Part 5 of the Town & Country Planning (Development Management Procedure) Order 2015
Approval of details reserved by condition imposed under ref. BE/135/18/PL relating to
Condition No. 12 (full permission) regarding surface water drainage at the Salt Box site.

Land at Salt Box, West of Shripney Road, Bognor Regis

Arun District Council have decided to **REFUSE details reserved by this condition**

The information submitted regarding Condition 12 imposed on full planning permission BE/135/18/PL: relating to surface water drainage at Unit 9, at the Salt Box site is refused and the condition is hereby not discharged

Drainage Layout
Sheet 1 of 2
- Drawing Status

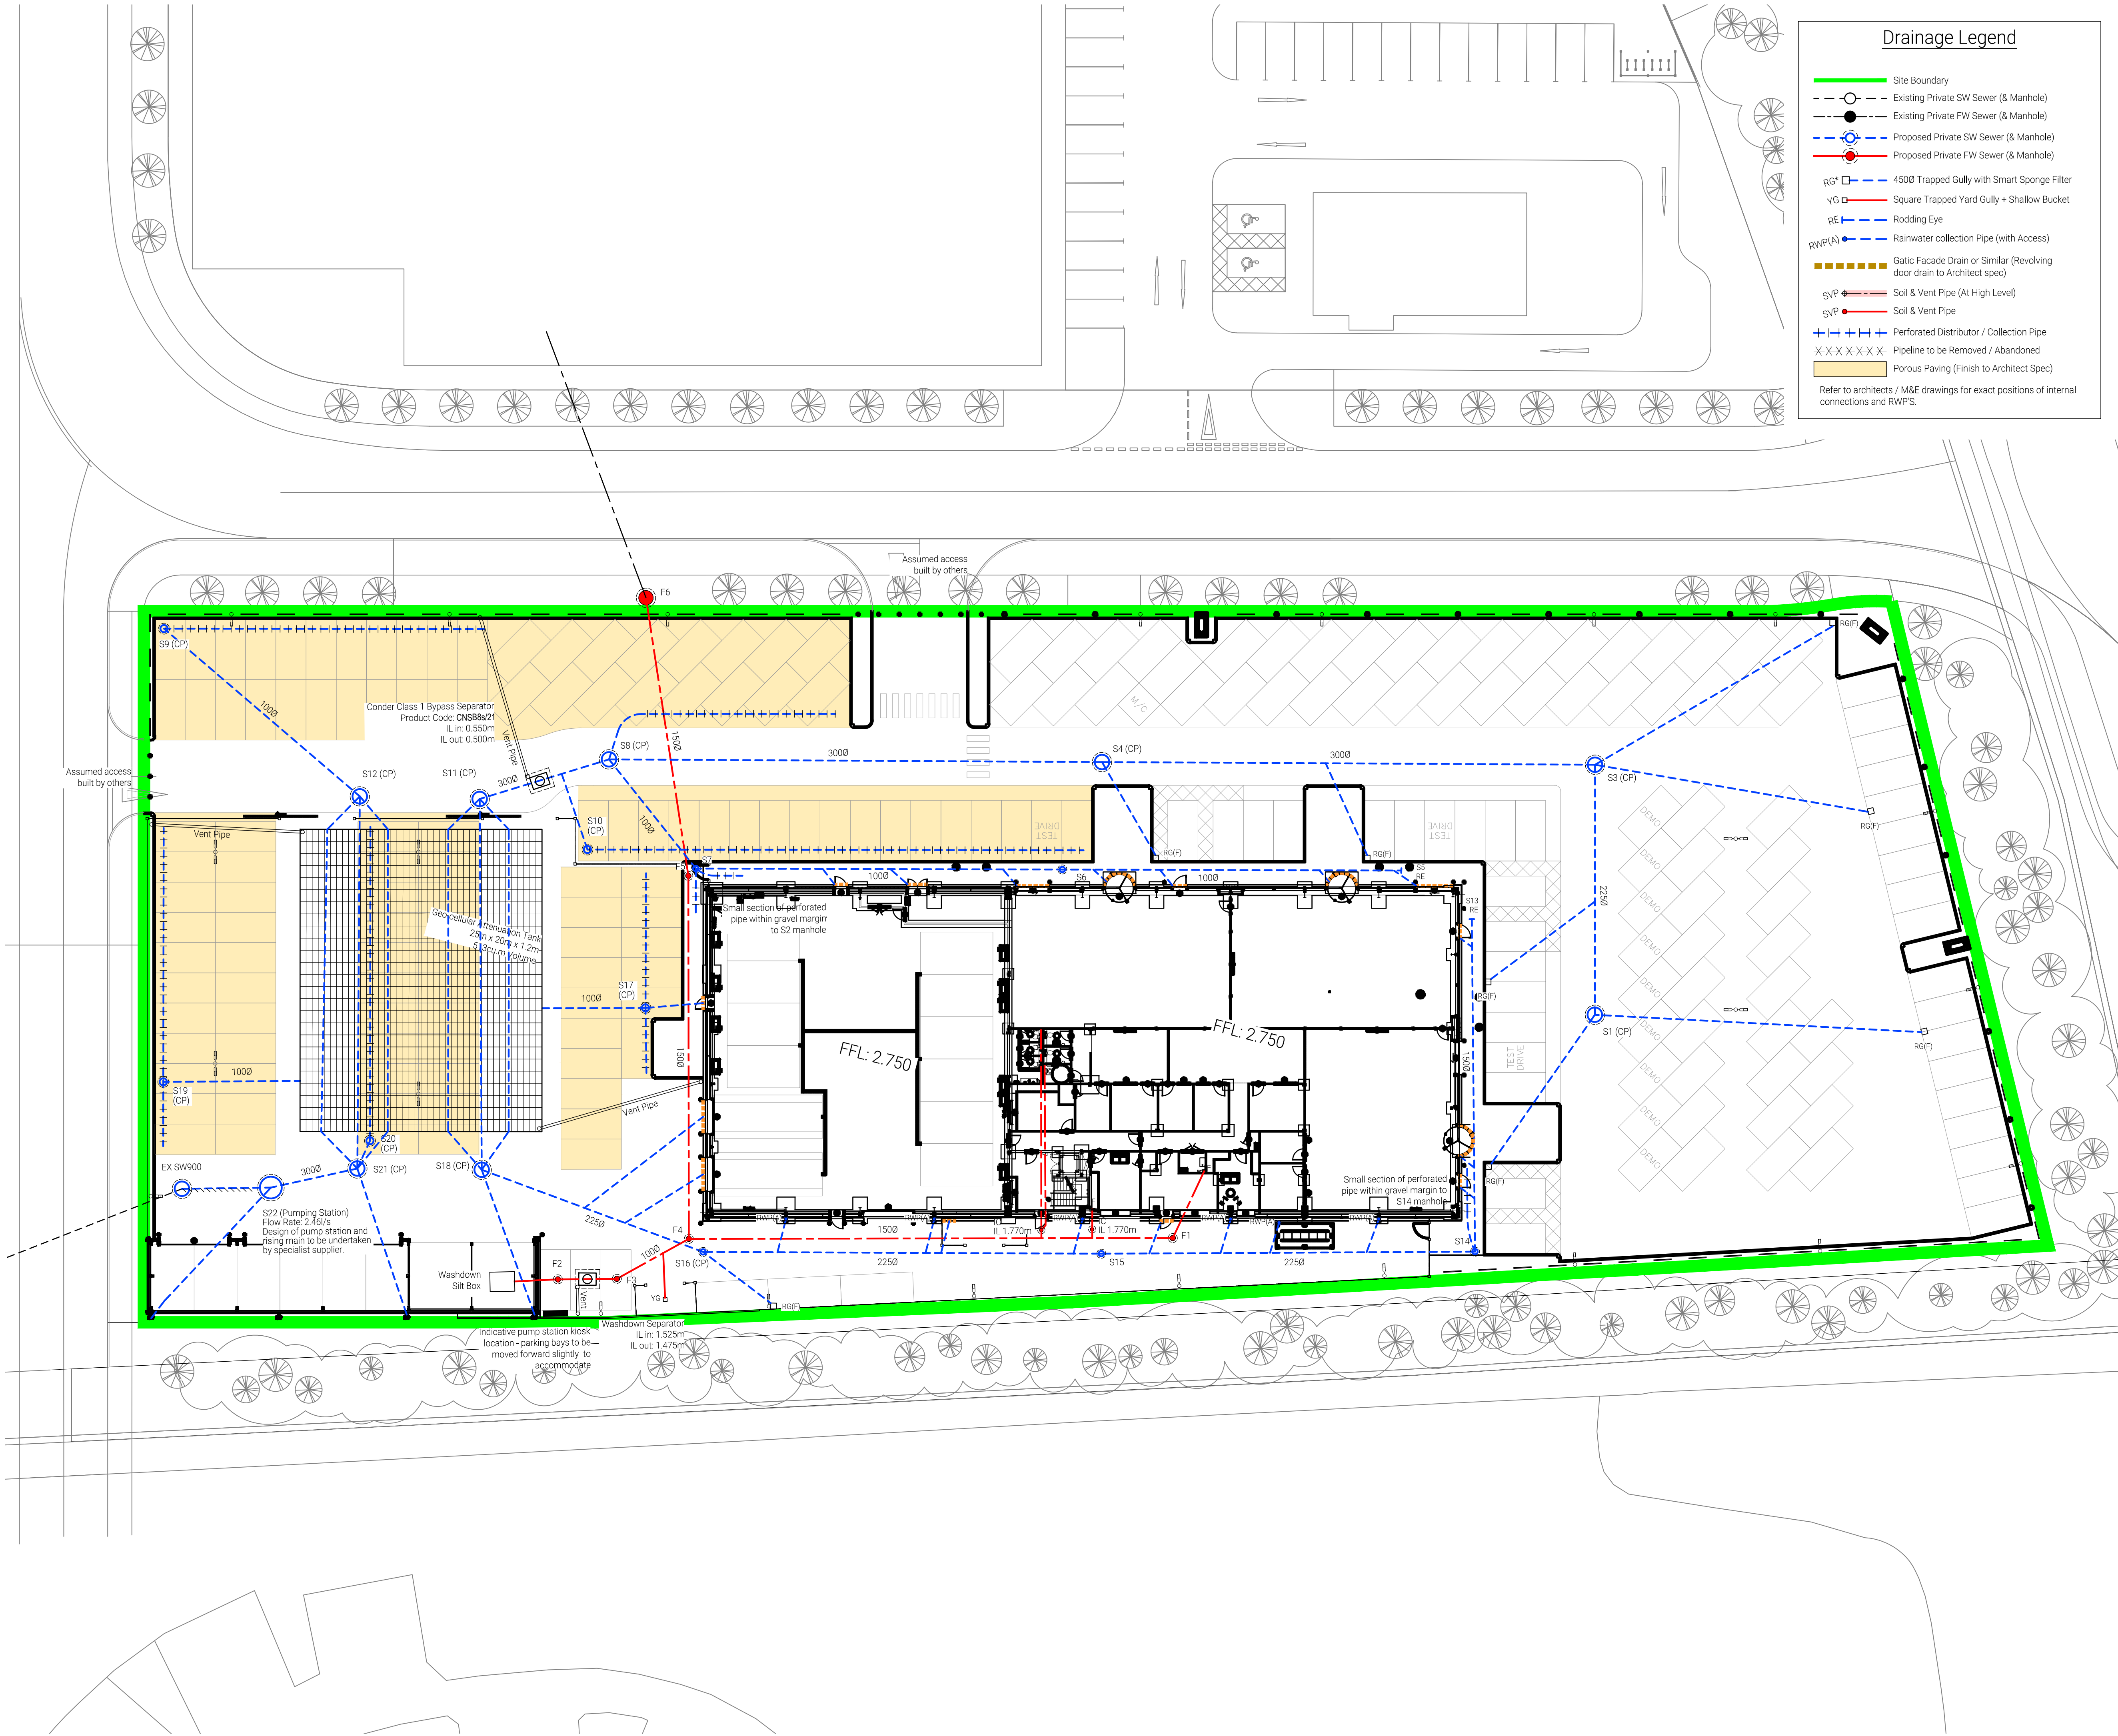
The scheme fails to provide a satisfactory solution i.e. a pumping station is being proposed, which is not sustainable and does not align with the envisaged strategy. A gravity solution must be achieved. Any proposal also needs to be supported by relevant hydraulic calculations to prove that the design storm can be accommodated on site. It is hereby confirmed that the proposed discharge rate of 2.46 l/s meets the requirements of the 'Hydrock' overall strategy. The applicant should expand the use of permeable paving where possible to improve water treatment, and this could also aid in providing additional shallow storage. All cover/invert levels and pipe gradients/diameters need to be included on the layout plan.
